AL/72/22/PL

Rock House Westergate Street Westergate PO20 3RJ

Demolition of Servac Int workshops keeping certain structures and features, to renovate them in to a 2 No carport, with storage loft and re-landscaping to provide new gardens and biodiversity zones.

West elevation - Roadside
1:50 @ A1

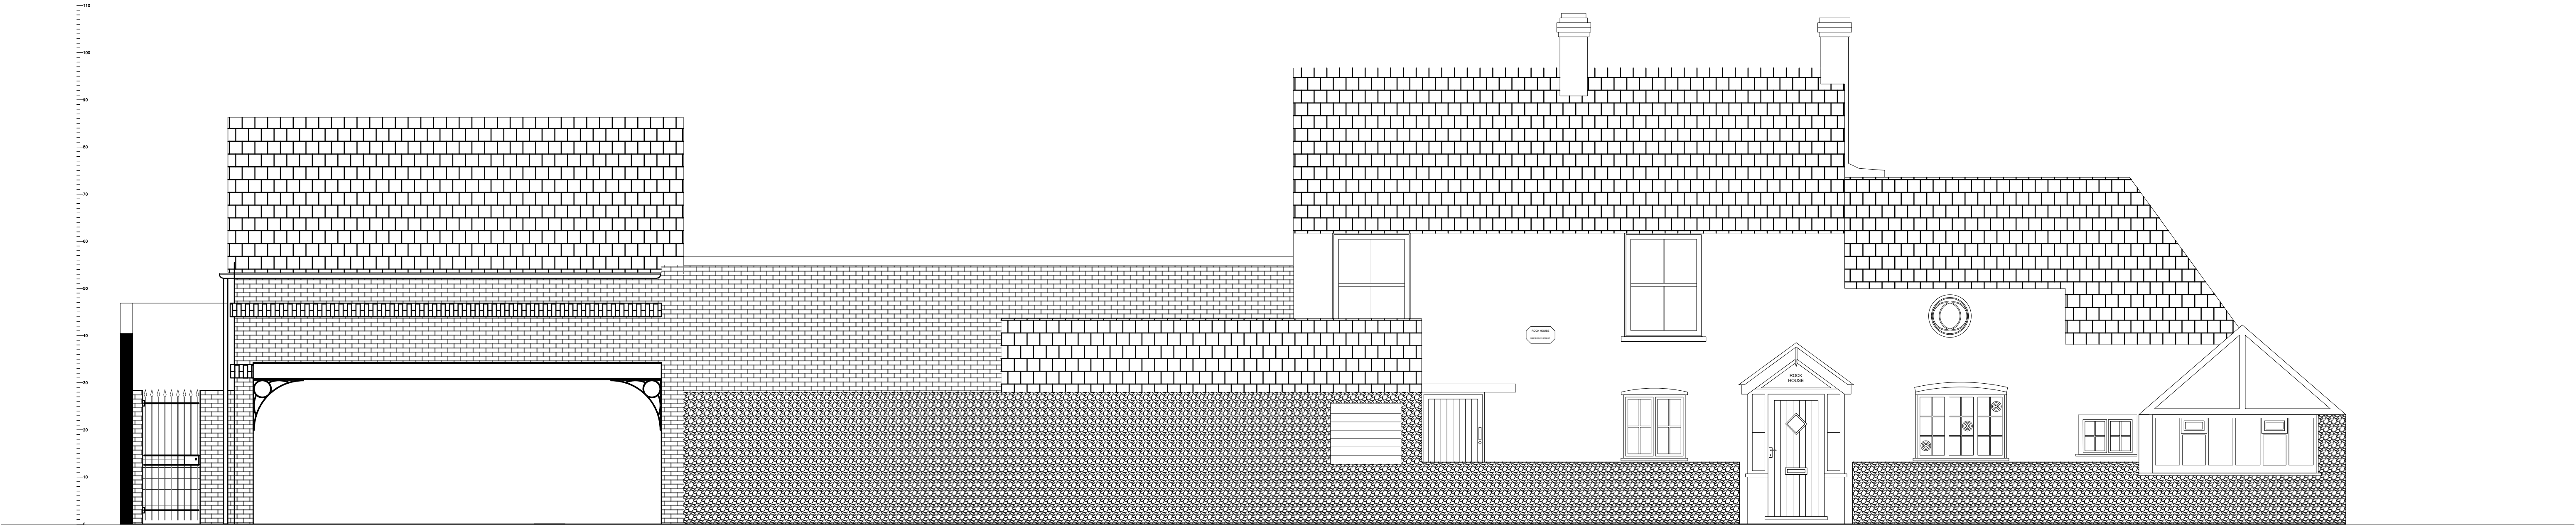
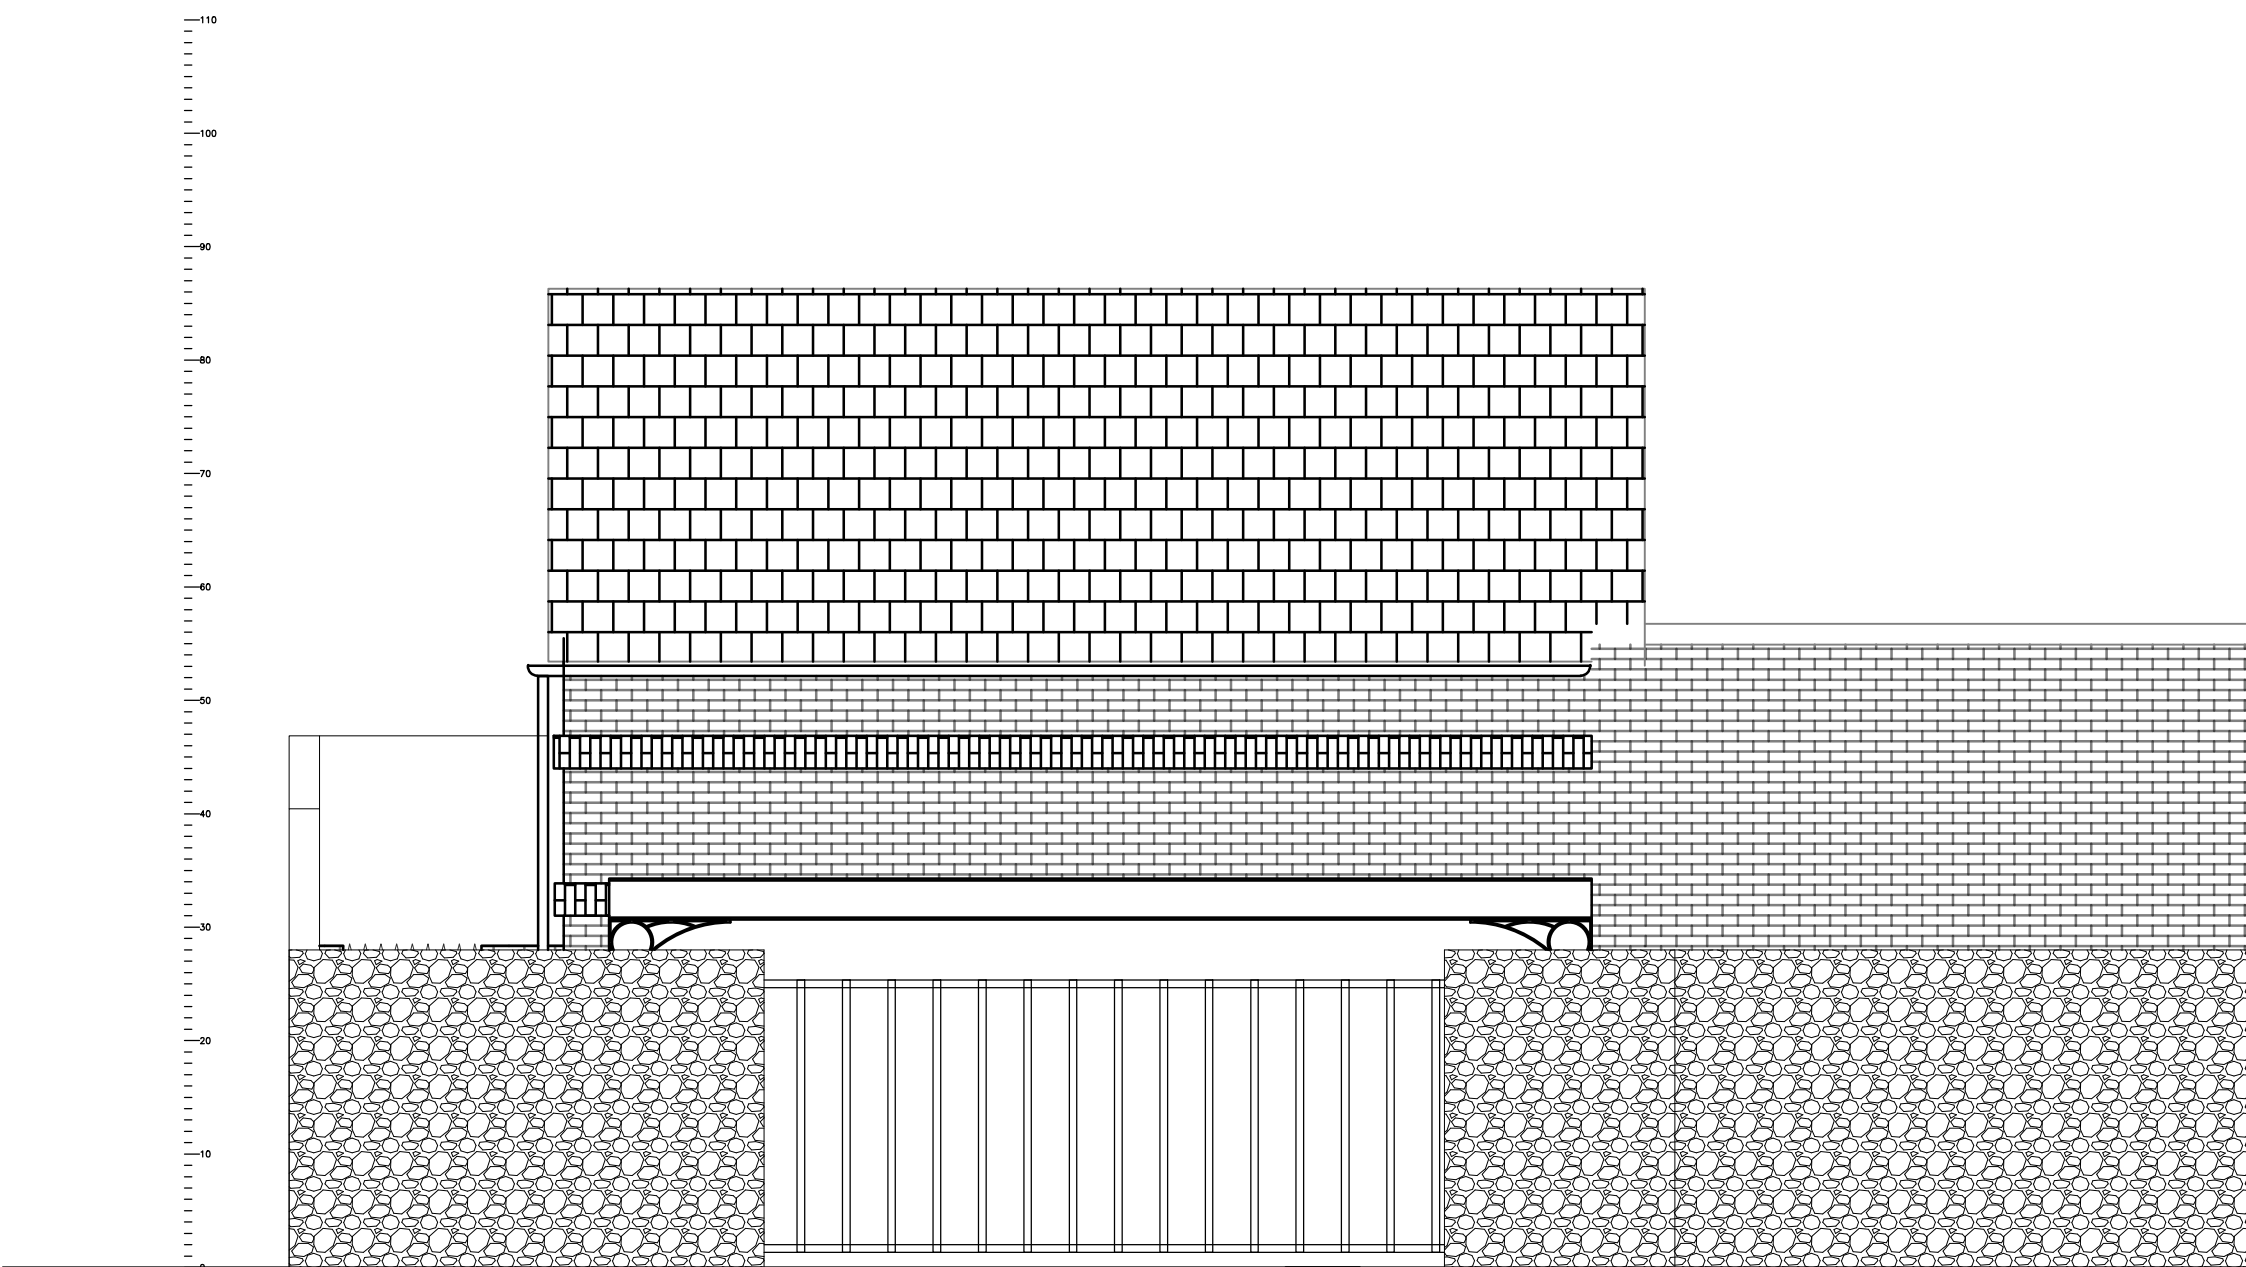
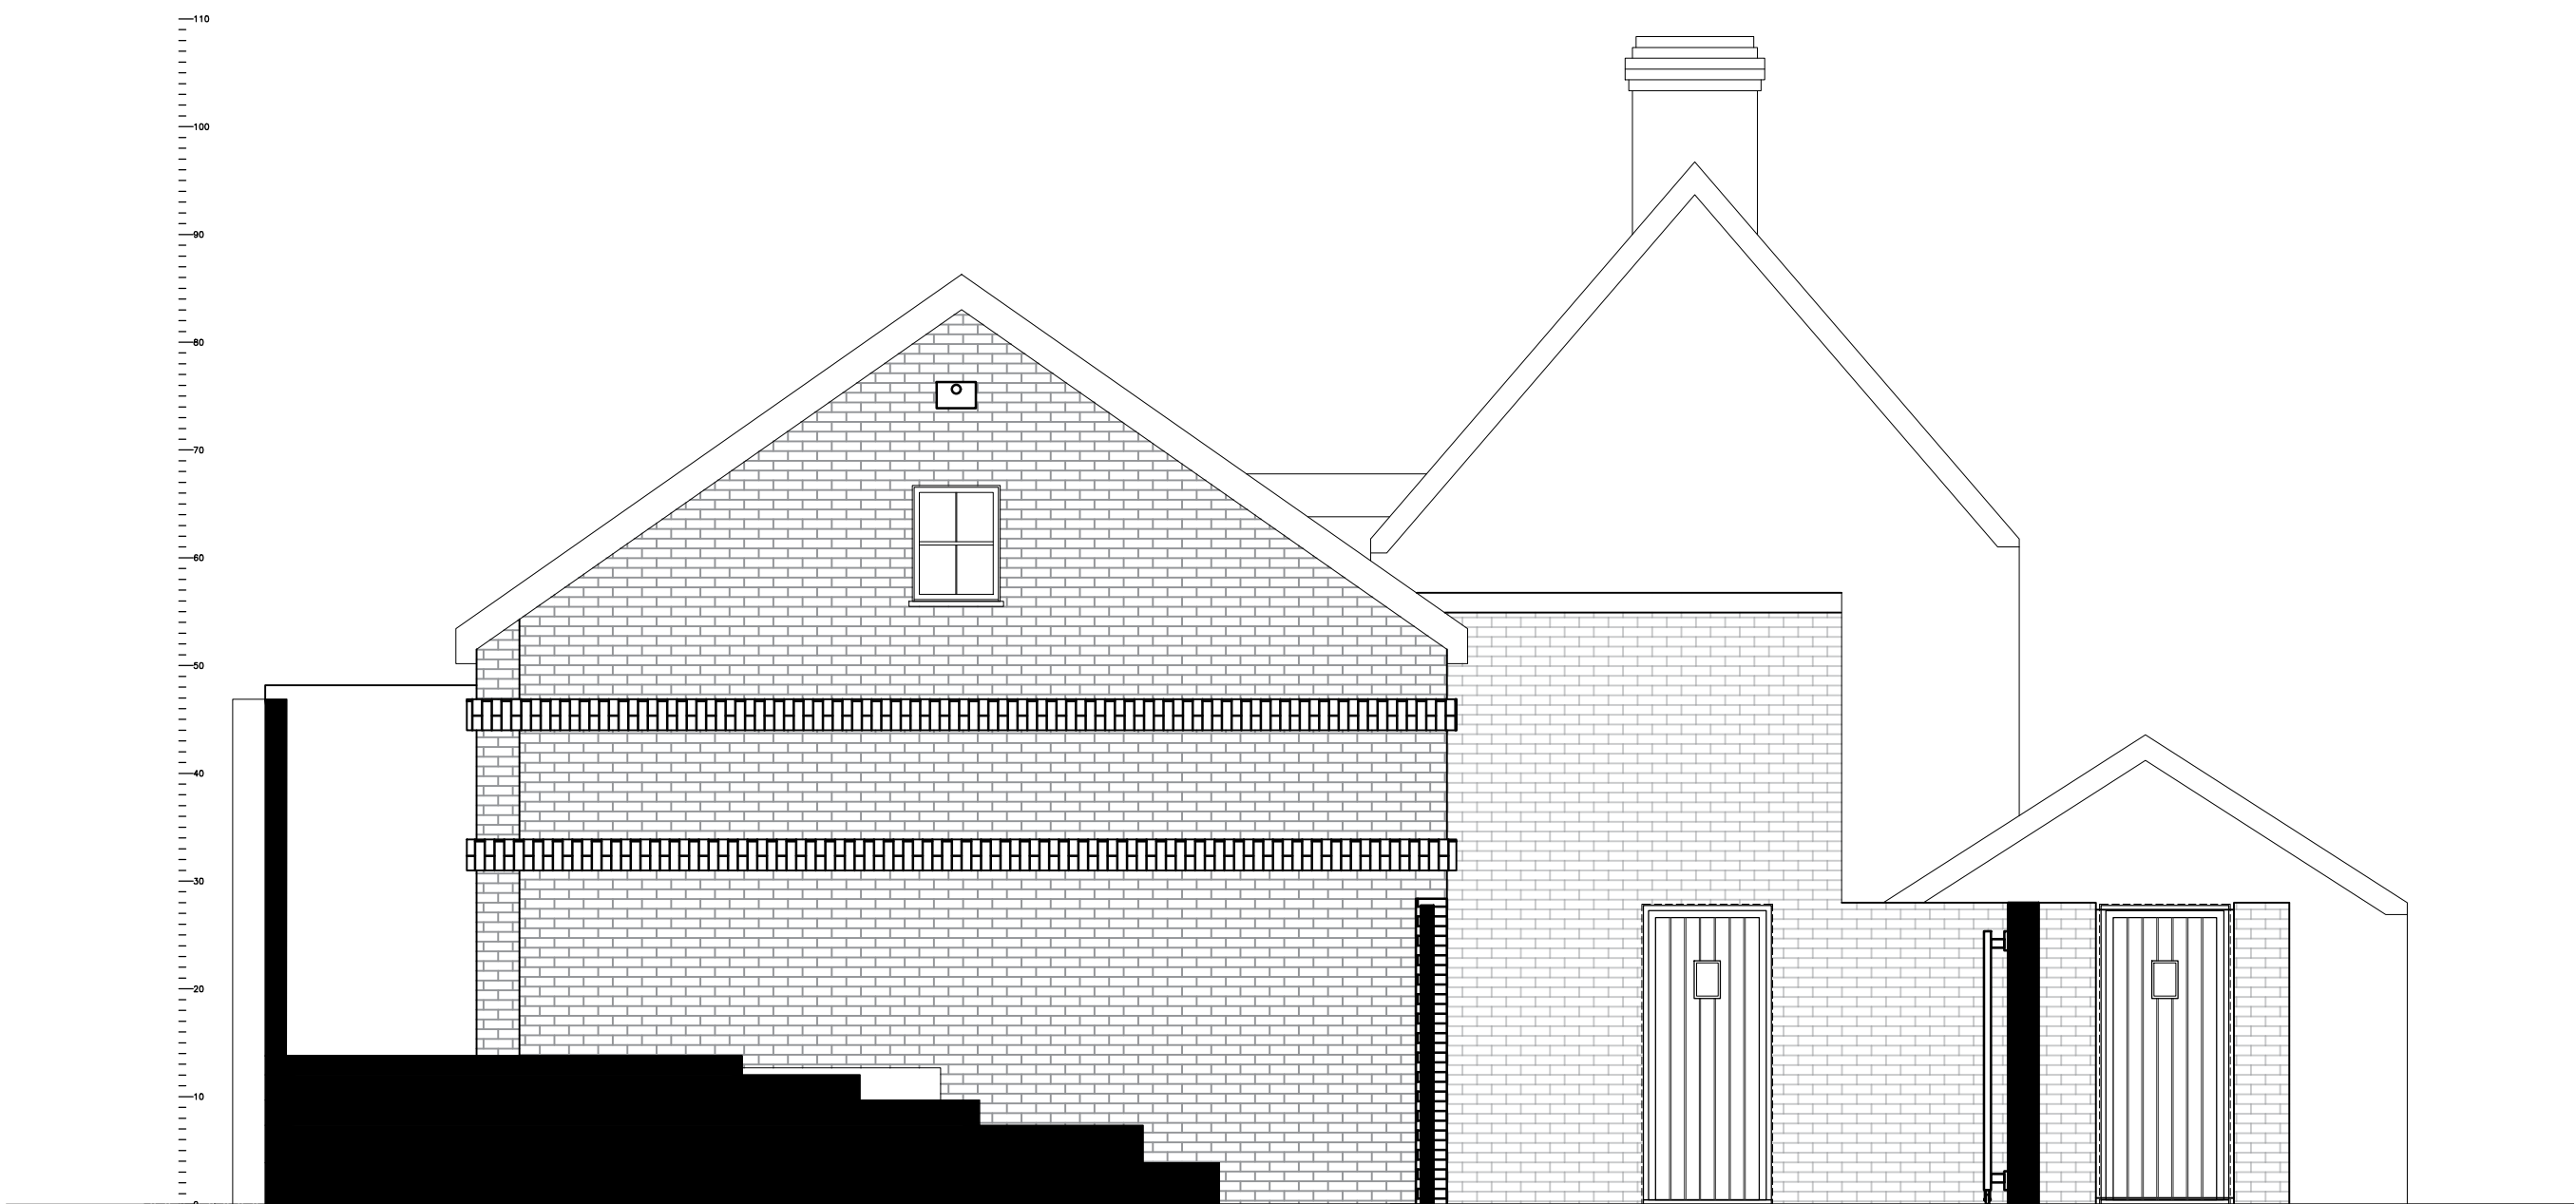
Point to note: The plans titles 'west elevation – roadside' appears to show that the proposed gate will cover the majority of the frontage of the car port with a small stretch of wall to the left hand side, whereas the ground floor plan implies that the same opening will cover the width of what is identified as 'car port 1', with a much larger stretch of wall. Which is correct?
